Charlotte Department of Transportation

Memorandum

Date: March 5, 2008

Subject: Rezoning Petition 08-052: Located on the northeast quadrant of the I-485/Albemarle Road Interchange

**Site Plan**

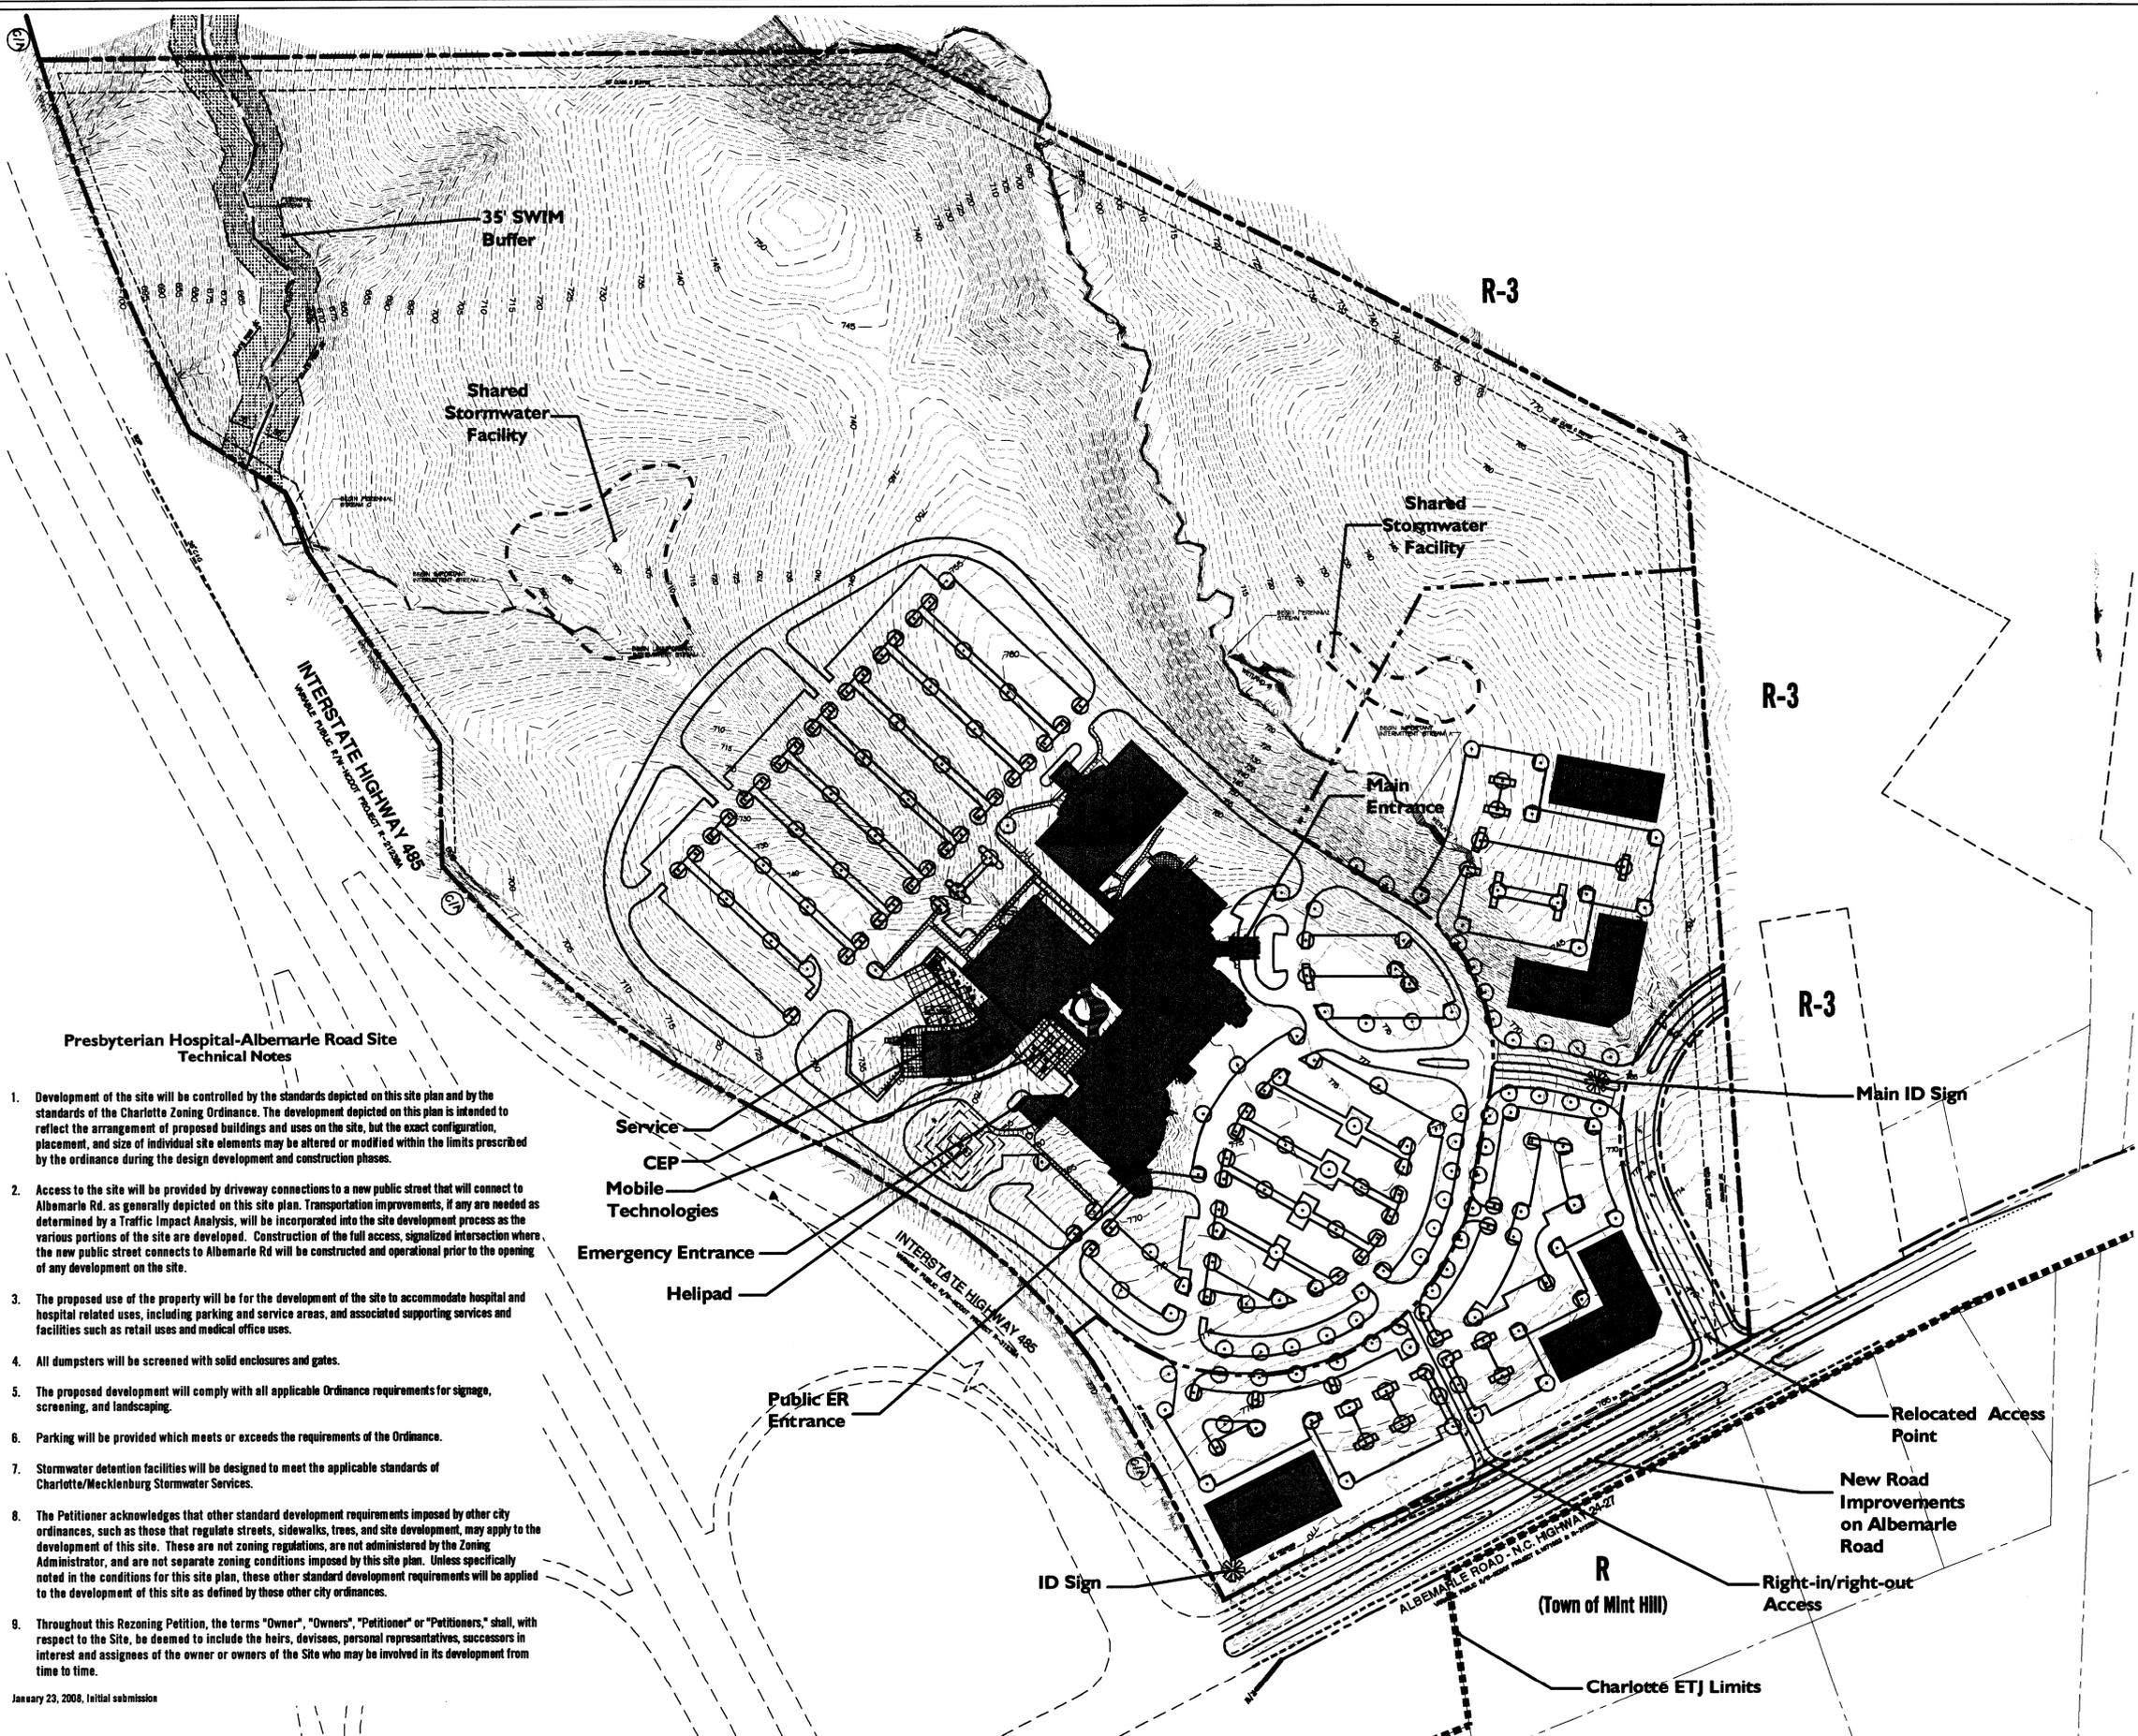
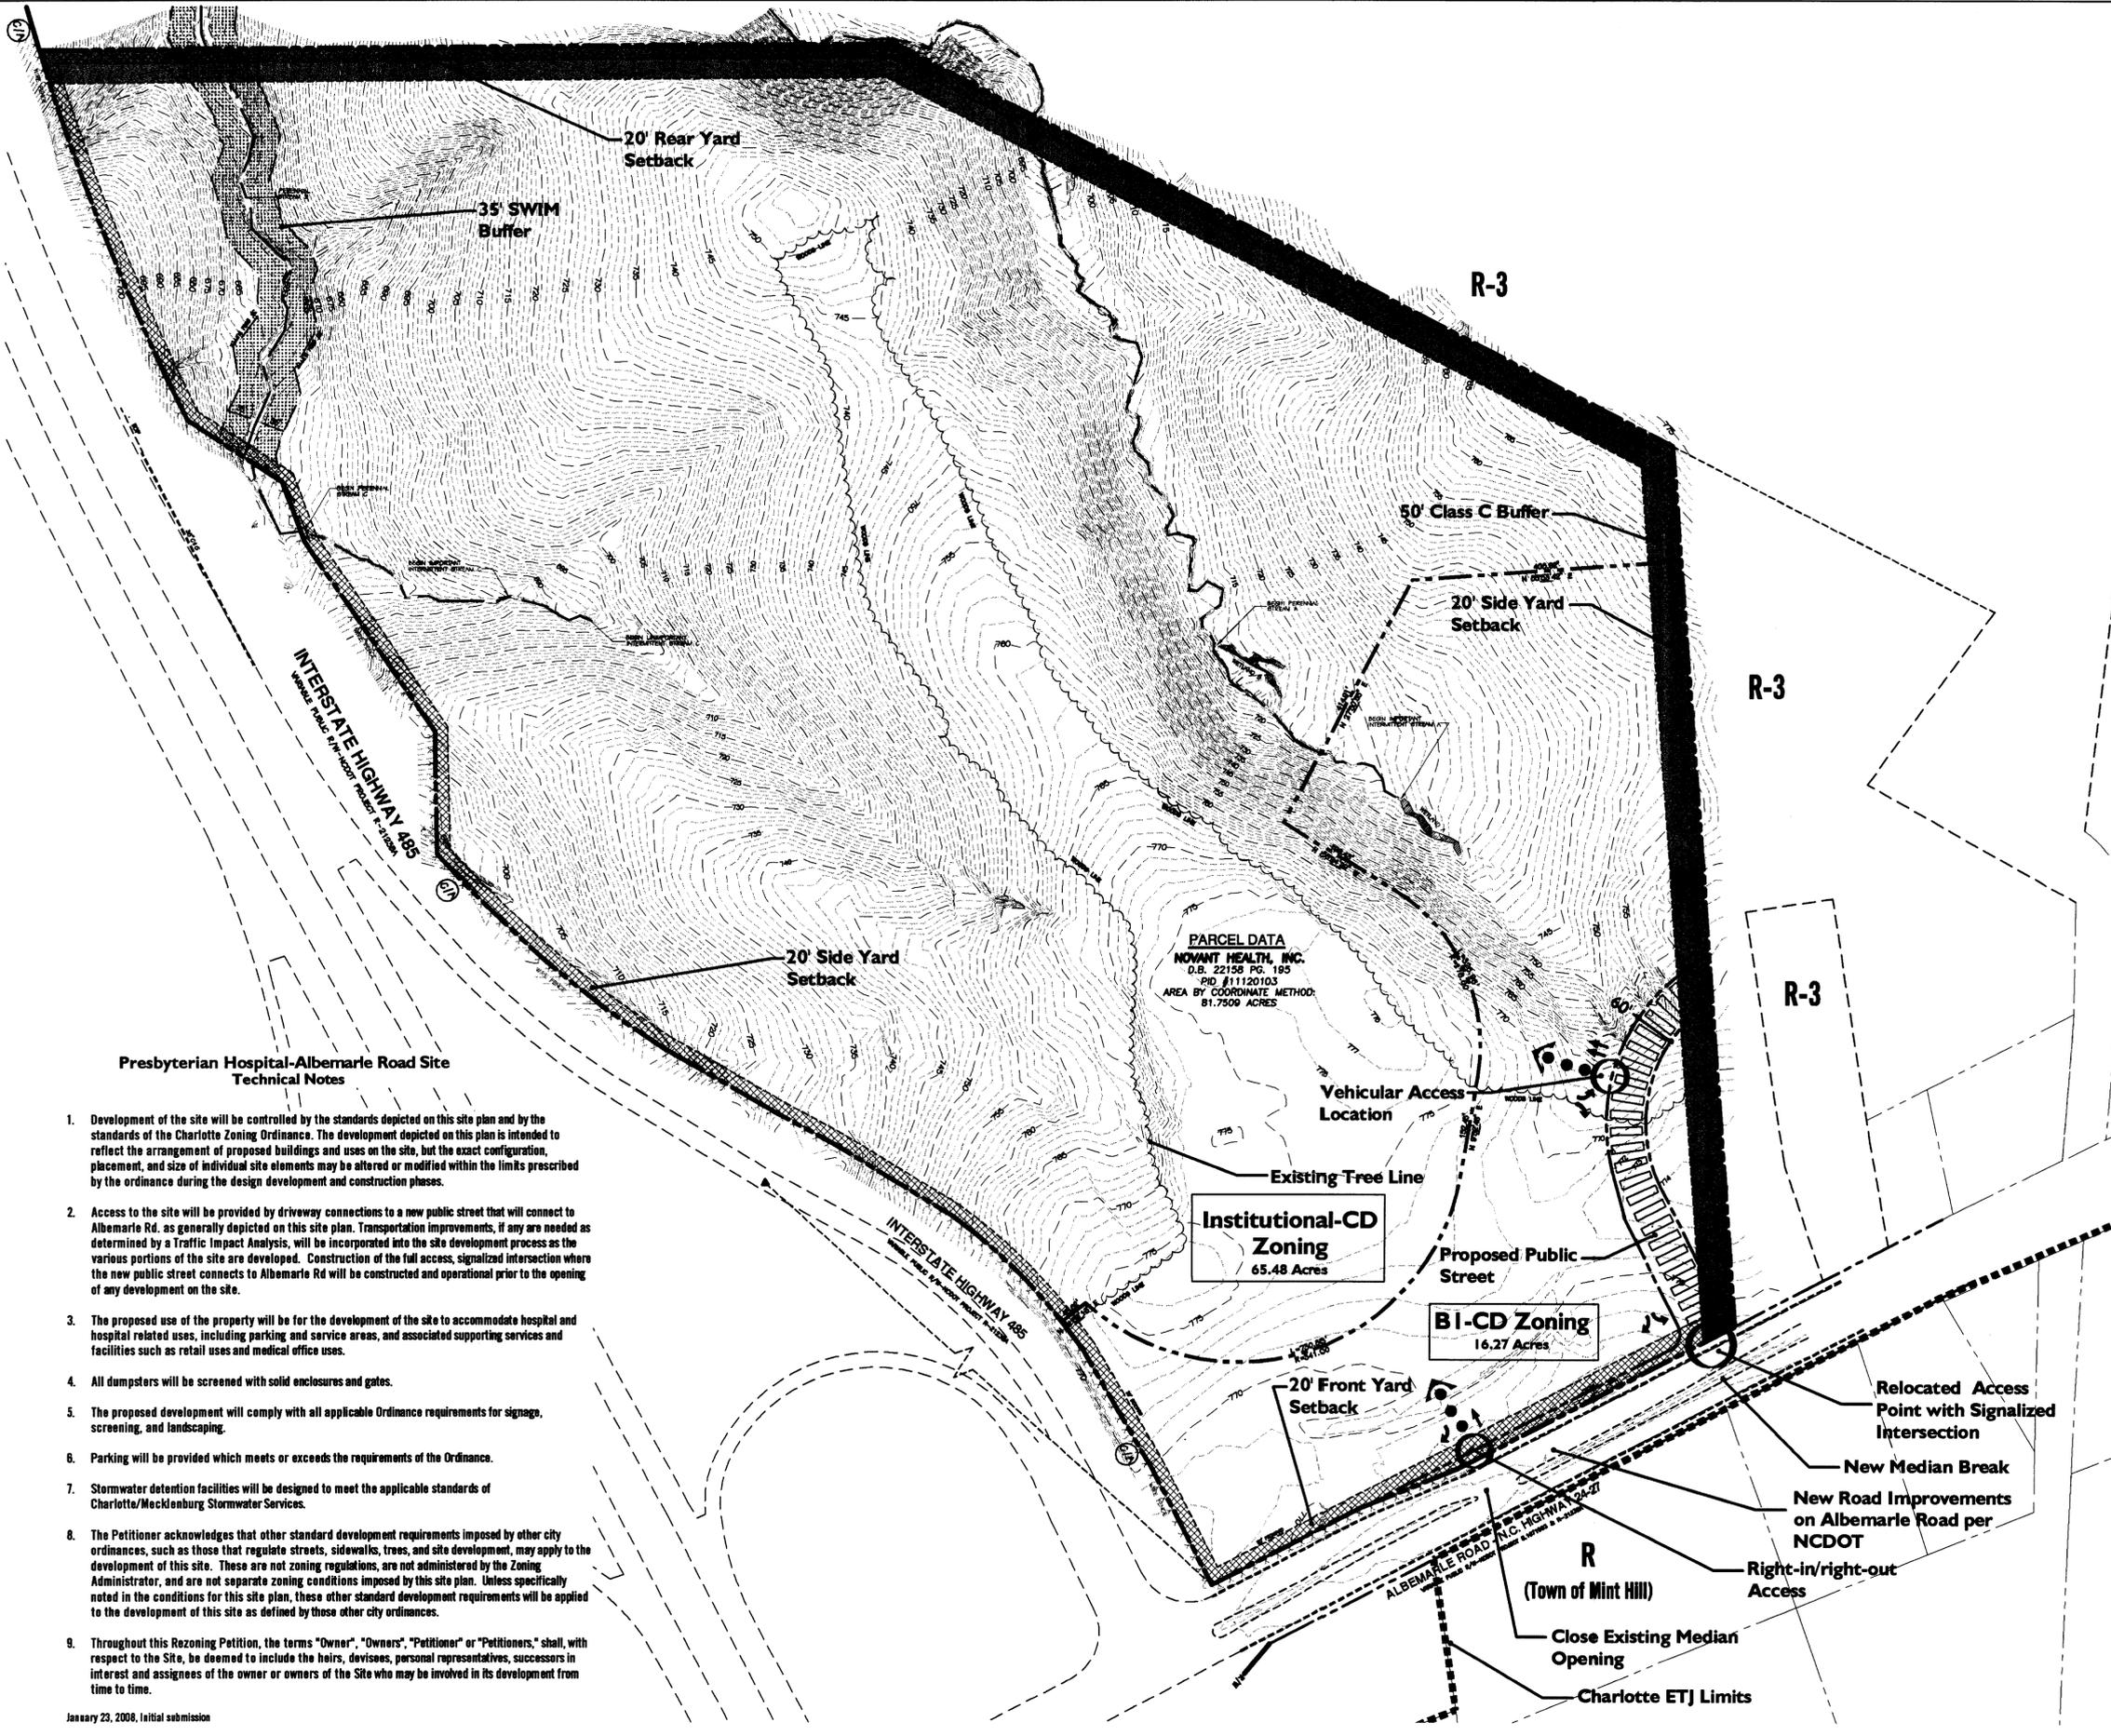
1. Albemarle Road (NC Highways 24/27) is designated a Strategic Highway Corridor by the NCDOT, requiring controlled/limited access. Albemarle Road is the only major east-west thoroughfare serving the eastern part of the City/County. There are no parallel major or minor thoroughfares south of Albemarle Road and none within 3 miles north of Albemarle Road. Significant future traffic volumes are projected on Albemarle Road and other than widening, there are few alternatives to increase capacity. There are limited future road projects identified in this area through 2030. Additionally, because the railroad is located south of and parallel to Albemarle Road, there is no practical way to increase the capacity of the existing Albemarle Road/I-485 interchange. In recognition of these capacity constraints and challenges, the Albemarle Road/I-485 Interchange Study Area Plan (approved by the City Council in 2003), limits the amount of non-residential development at this location. The interchange study also indicates that no access point should be within 1,300 feet of the I-485 interchange and that any access point within 0.5 mile of the interchange should be limited to right-in/right-out movements only. Given that this site has frontage (865 feet) less than required for full access (2,600 feet), only the eastern-most access location is acceptable and will only be permitted for right-in/right-out turning movements. Additional access to this site will need to be provided consistent with the adopted area plan as described in comment 3.

3. The adopted area plan also includes necessary internal street connections for this site/adjacent sites. In particular, the adopted plan includes a new public street from this site parallel and north of Albemarle Road and connecting with a new north-south Major Collector Street. This Major Collector is identified on the adopted Major Collector Street Plan and connects Camp Stewart Road with Albemarle Road at the location of the first full access intersection identified in the Albemarle Road/I-485 Interchange Study Area Plan. CDOT/CMPC support of the requested area plan changes is also dependent on the construction of this east-west connector by the petitioner. The petitioner does not currently own all of the property to the east that is needed to construct this roadway, however, the City will assist in right-of-way acquisition in accordance with standard practice through the subdivision process. The petitioner is responsible for all cost associated with design, construction, and the acquisition of right-of-way. CMPC/CDOT has scheduled a meeting on March 20th to discuss the project with the adjacent property owners. The developer of a

4. The street system shown on the plan needs to include a public street stub to the north residential property. This is a requirement from the design charrette and follows guidance from the Subdivision Ordinance. The location of the stub needs to be coordinated with the adjacent property owner.

5. We have discussed access for this site with the NCDOT Division and District Engineers. Special left-turn access designed for exclusive use by emergency vehicles will be considered at a location that does not conflict with the interchange ramp intersection, westbound right-turn lane, and directly serves the emergency entrance area only with no connections to other uses or parking areas. The traffic impact study will need to address the issue of maintaining access exclusivity for emergency vehicles and whether a left-turn lane is recommended/required at this location. Based on CDOT's and NCDOT's review the driveway may be restricted to ingress only. The site plan needs to be revised to show this separate/dedicated emergency vehicle access.

6. The Urban Street Design Guidelines (USDG) identify Albemarle Road as a Parkway, the most motor vehicle-oriented of Charlotte's street types. For Parkways, the USDG requires special designs for access controls and separate bicycle/pedestrian paths parallel to the roadway. Applying USDG for a Parkway, a 10-foot minimum bicycle/pedestrian path constructed 25 feet from the back-of-curb should be provided along Albemarle Road. The site plan needs to show and label these features.

1. The appropriate street type for the new street connecting to Albemarle Road at the east edge of the site and continuing to the Major Collector as described above (comment 3) is an Avenue (USDG). Bike lanes (5' minimum width) need to be provided on Avenues.
2. It is requested that the site plan provide an internal system of 5-foot or wider sidewalks that connects building entrances to sidewalks along all new streets and the bicycle and pedestrian path along Albemarle Road.
3. Required parking calculations need to be included on the plan to evaluate if the plan can accommodate required parking and traffic flow.

4. A note needs to be added to plan stating that it is conceptual in nature and that where conditions on the approved conceptual site plan differ from ordinances, standards, and policies in place at the time of engineering plan review in subsequent permitting processes, the site plan will be revised to meet or exceed current standards.

1. A designated area in the parking lots needs to be designated for a Park-N-Ride facility.

Adequate sight triangles must be reserved at the proposed street entrance. Two 35' x 35' and two 10' x 70' sight triangles are required for the entrance to meet requirements. All proposed trees, berms, walls, fences, and/or identification signs must not interfere with sight distance at the entrance(s). Such items should be identified on the site plan.
